Utah Lane Site Development Plan

May 1, 2019

Address: 7340 Utah Lane

BSK INVESTMENTS LANDSCAPE PLAN EL PASO COUNTY, COLORADO

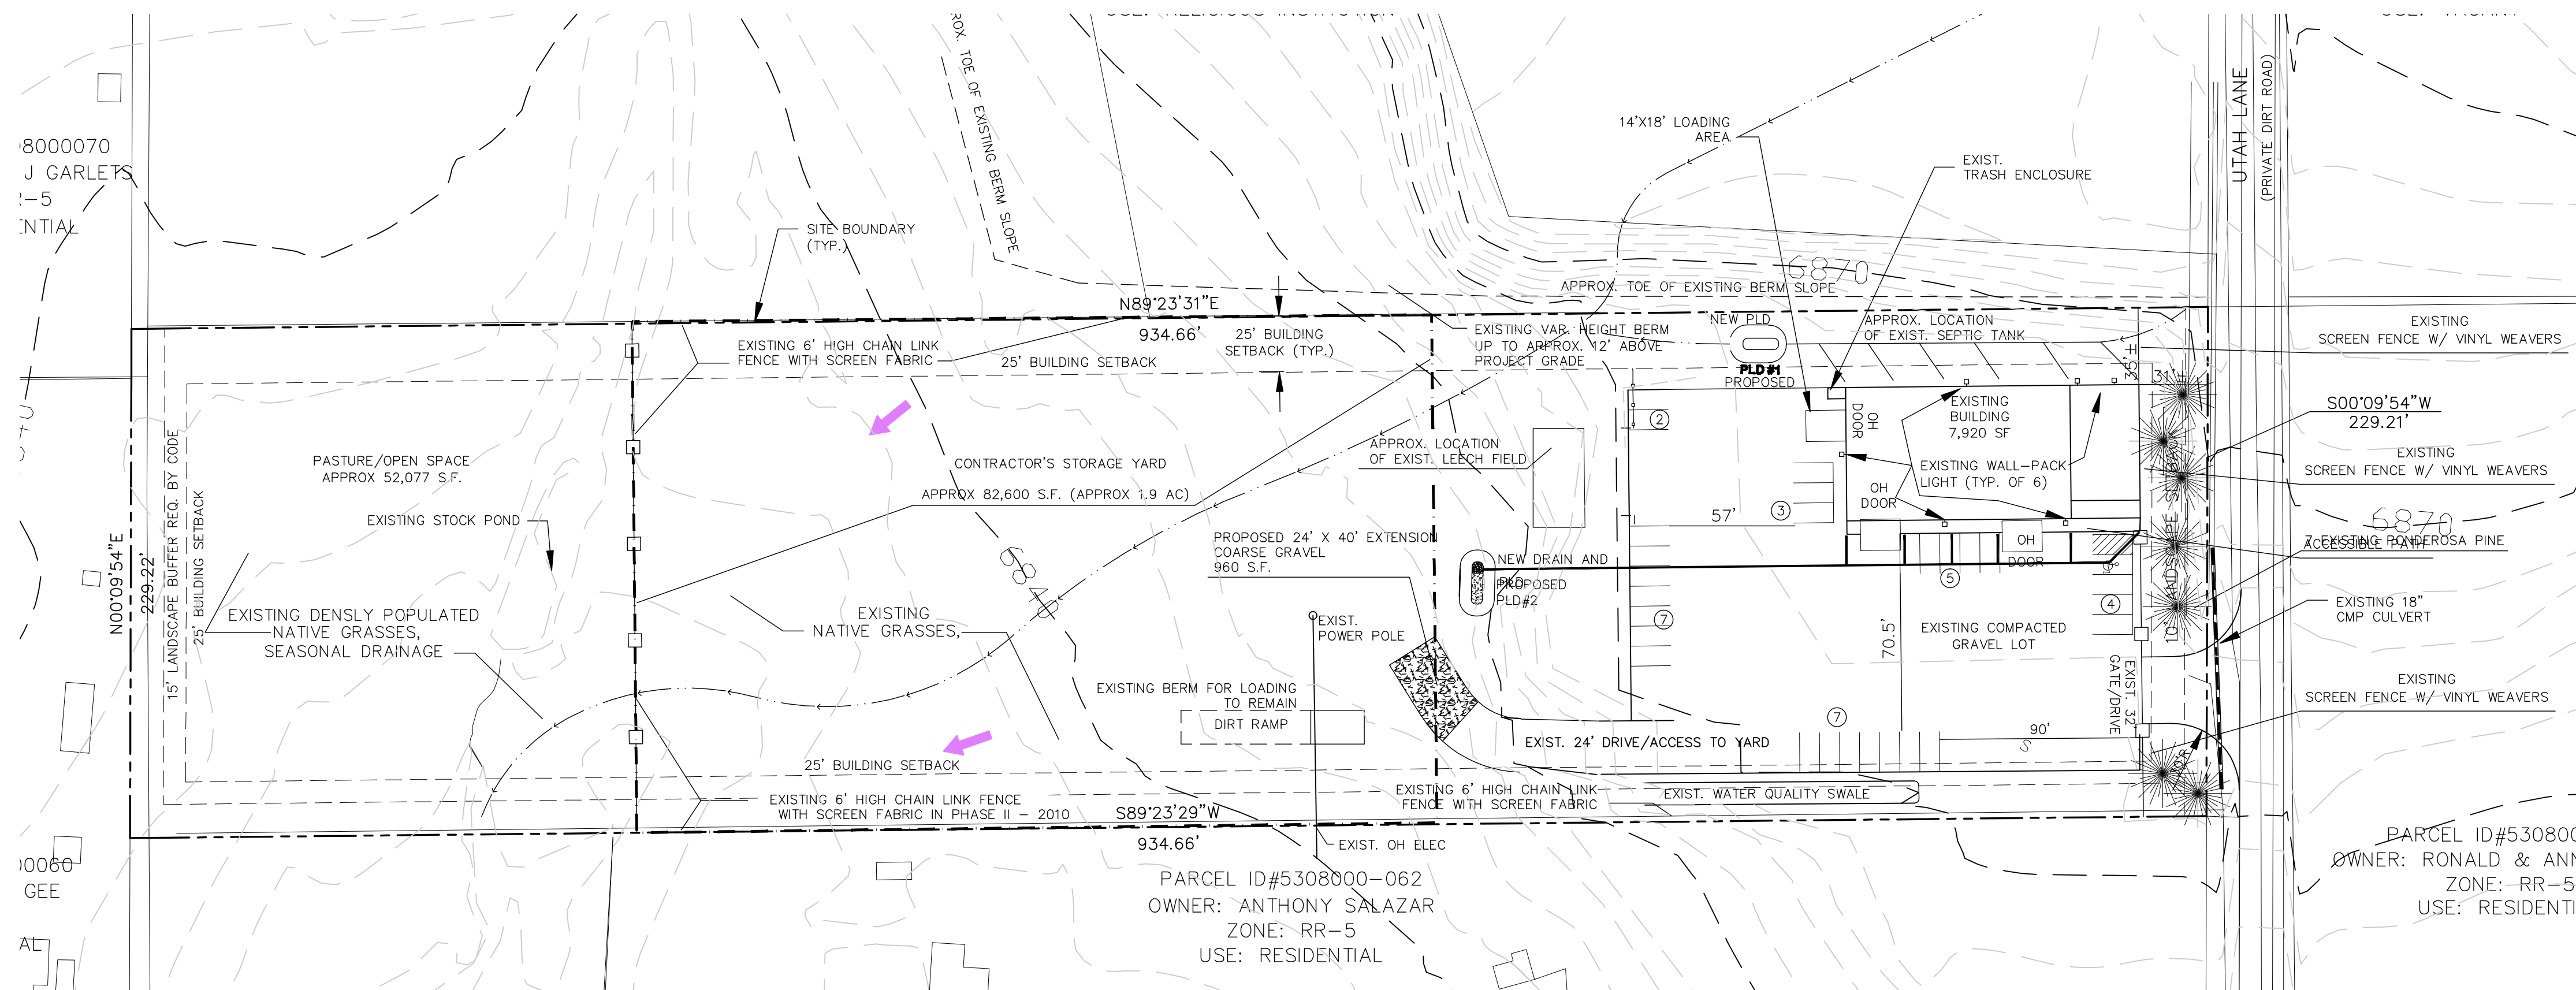
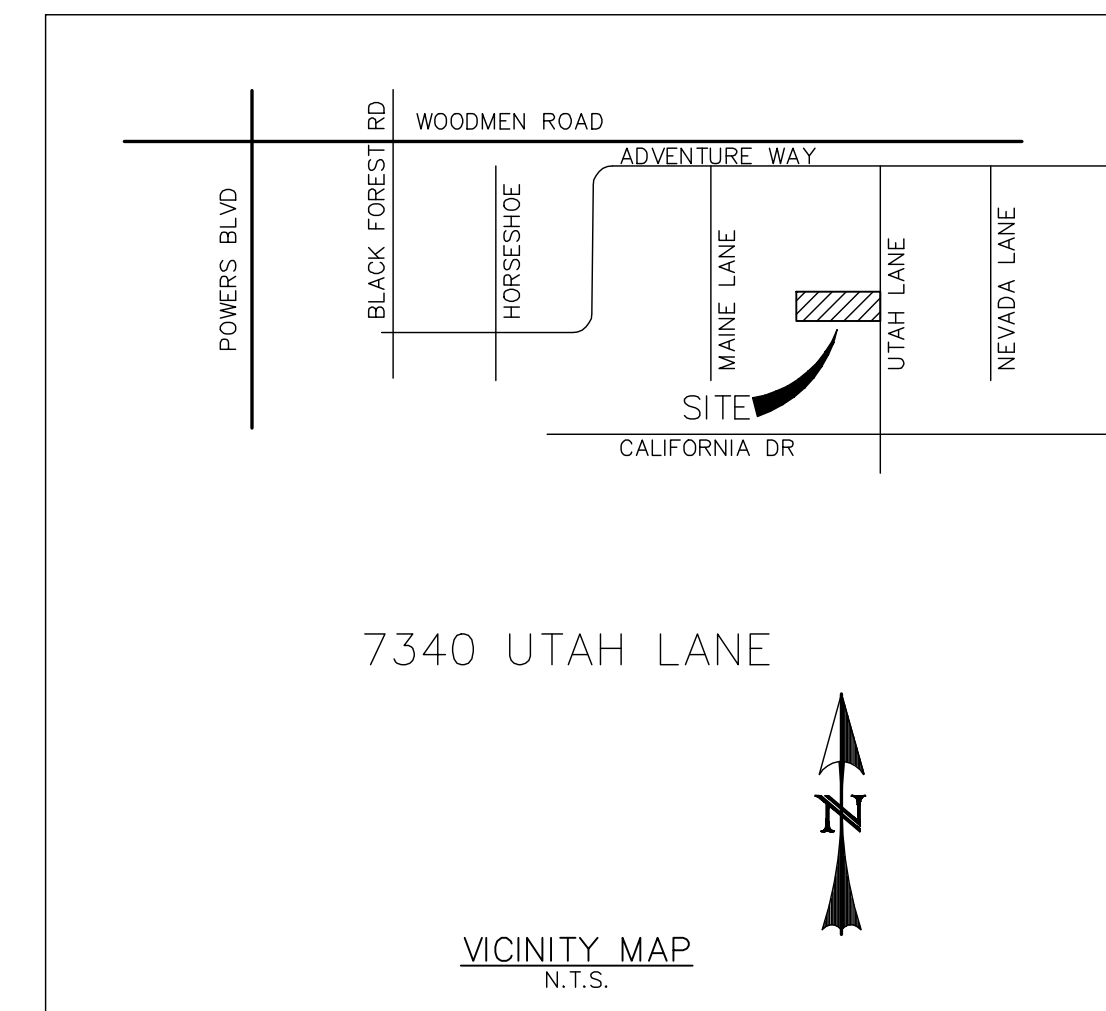
Provide justification for this alternative landscape request
(IE why the trees are not provided this time when a new site
plan is proposed.)

The Landscape plan illustrates that all but a parking requirement of 2 parking lot trees are actually met on this site.
